DRB Application No.: 04DRB-01069 (P&F)
Project Name: Town of Atrisco Grant Airport Unit
Agent: Doug Smith

**CITY OF ALBUQUERQUE
PLANNING DEPARTMENT
Development Review Board
July 14, 2004 Comments**

Re: Tract 218, Town of Atrisco Grant/minor plat

**PLAT
OF
TRACTS 218-A AND 218-B
TOWN OF ATRISCO GRANT
AIRPORT UNIT**

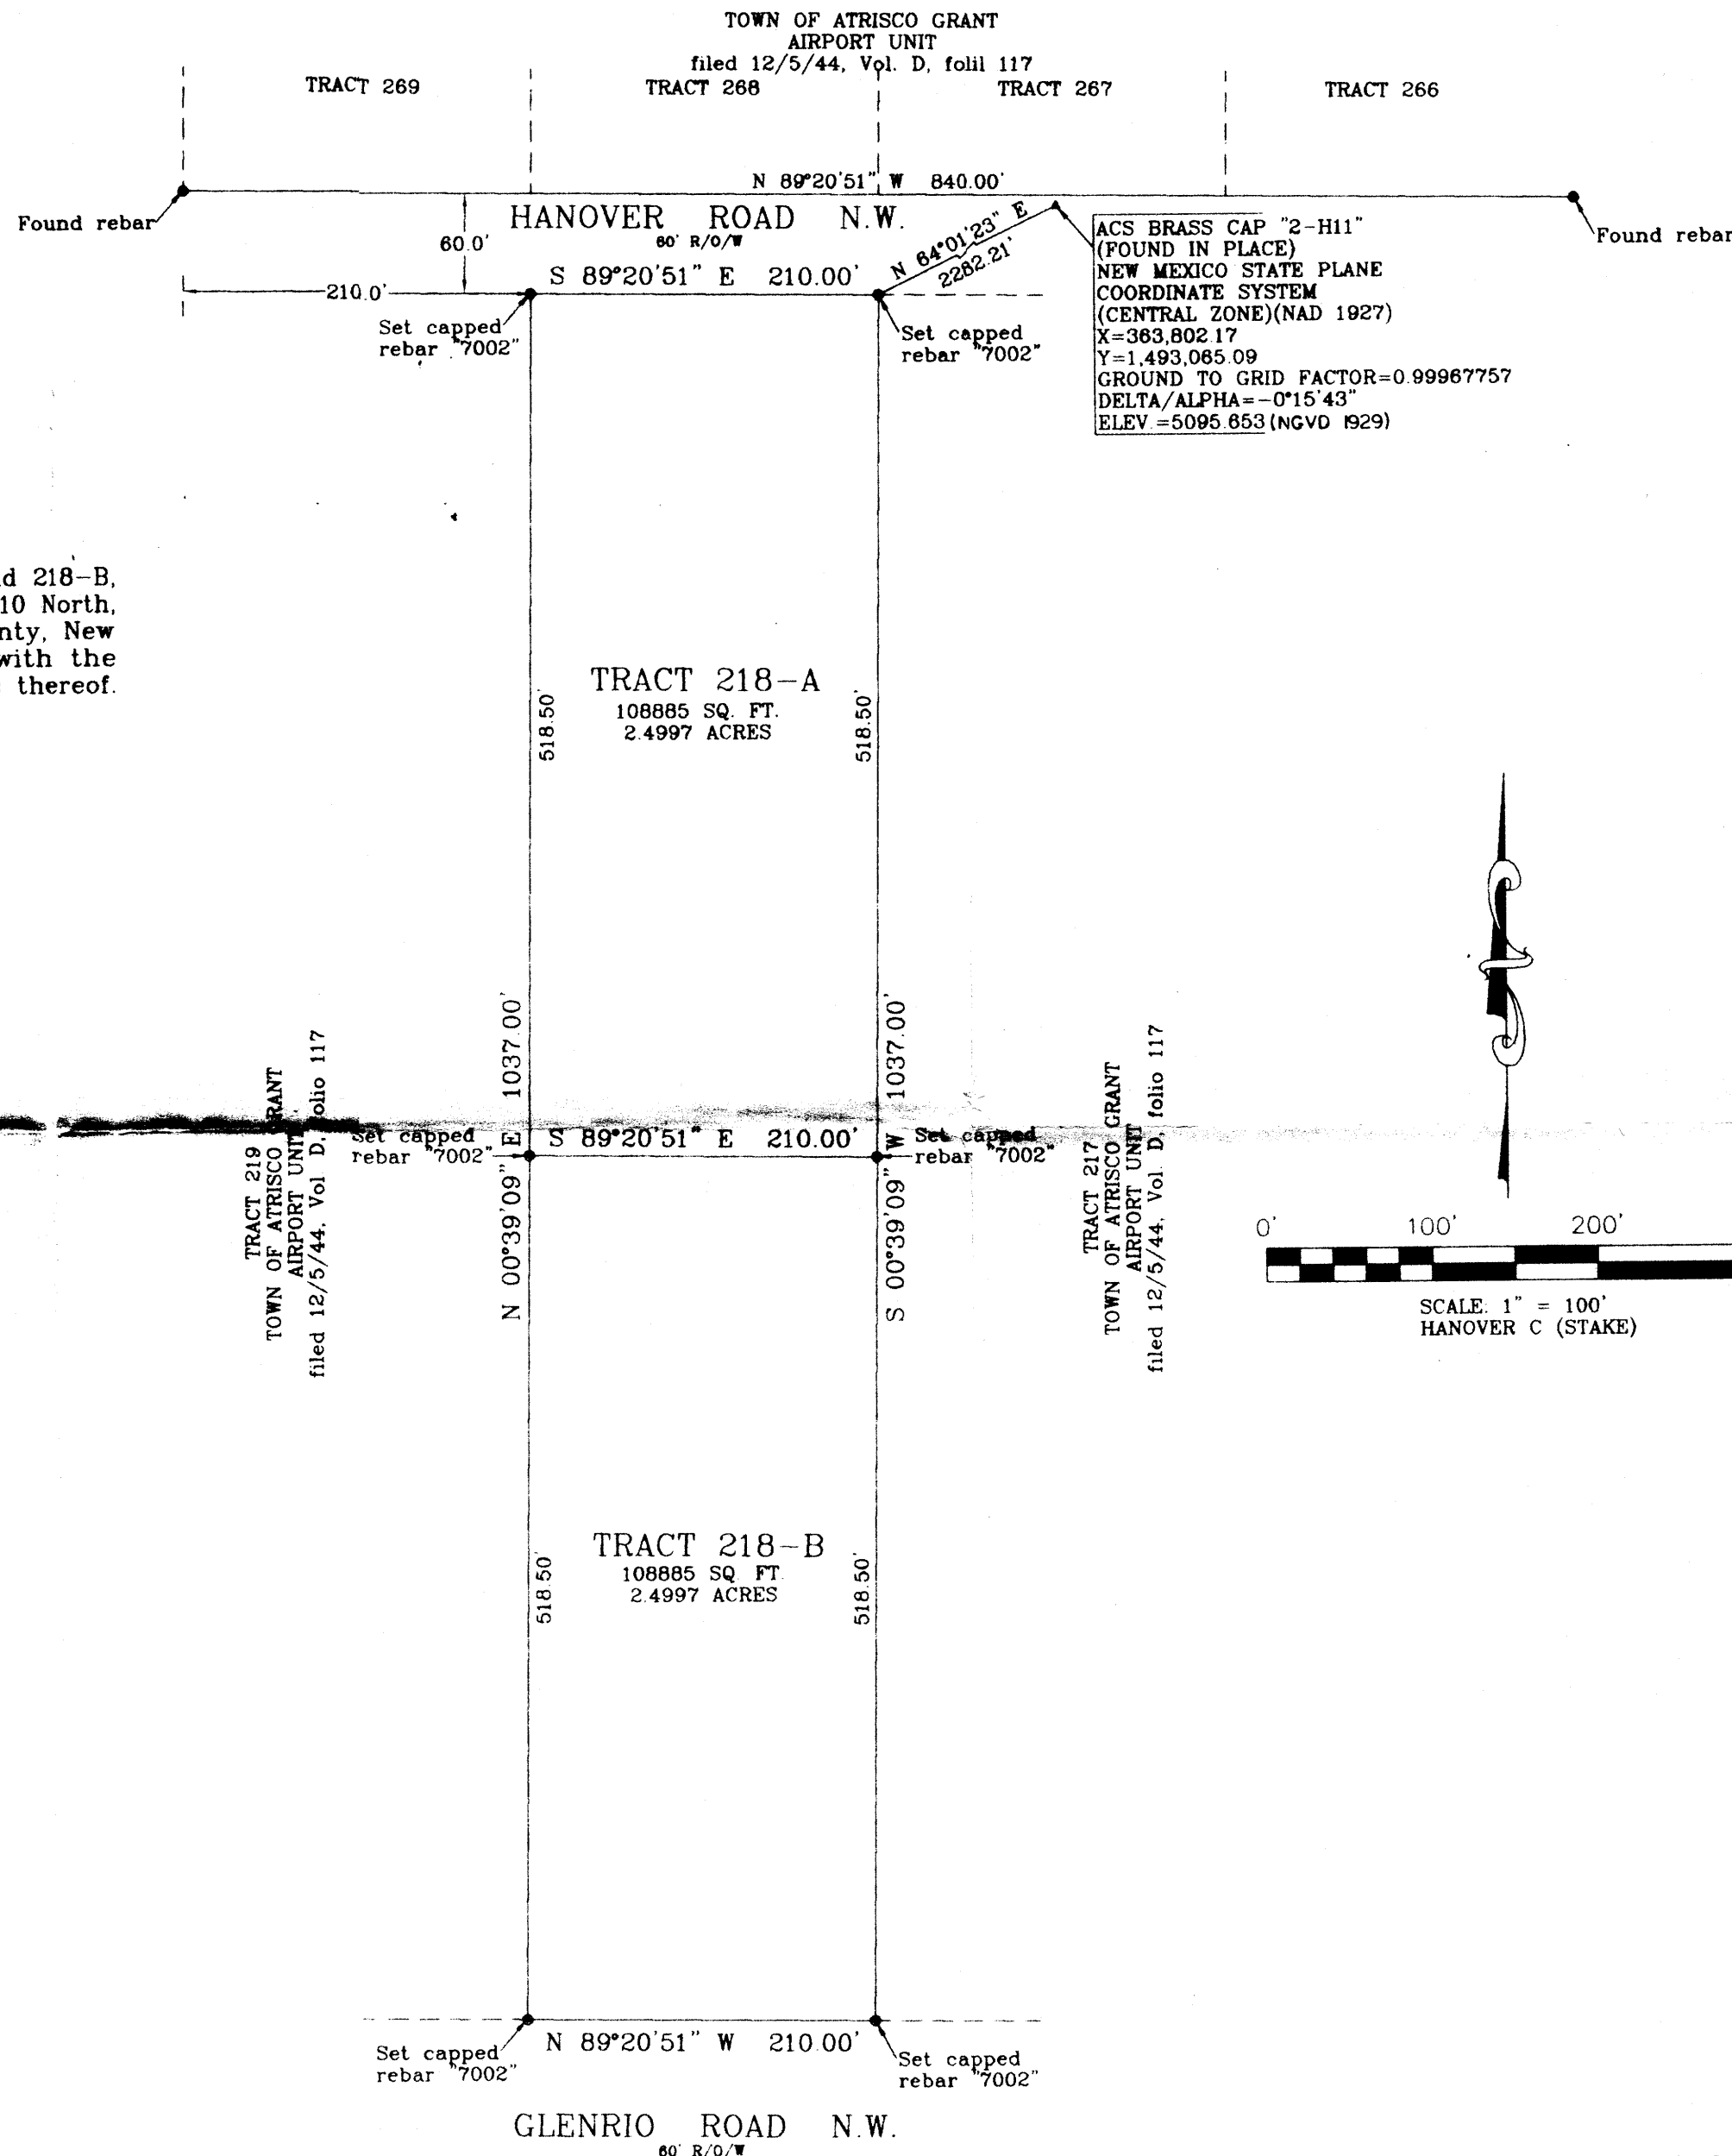
No objection to the proposed replatting action.

Prior to sign-off on the final plat, a fee in-lieu of and equal to the value of the required park land dedication for 1 new residential lots will be required. The fee will be based on an estimate of land value to be provided by the City Real Property office. Alternatively, the applicant may submit current appraisal information mutually acceptable to the applicant and the City.

An approved infrastructure list is required for Preliminary Plat approval.
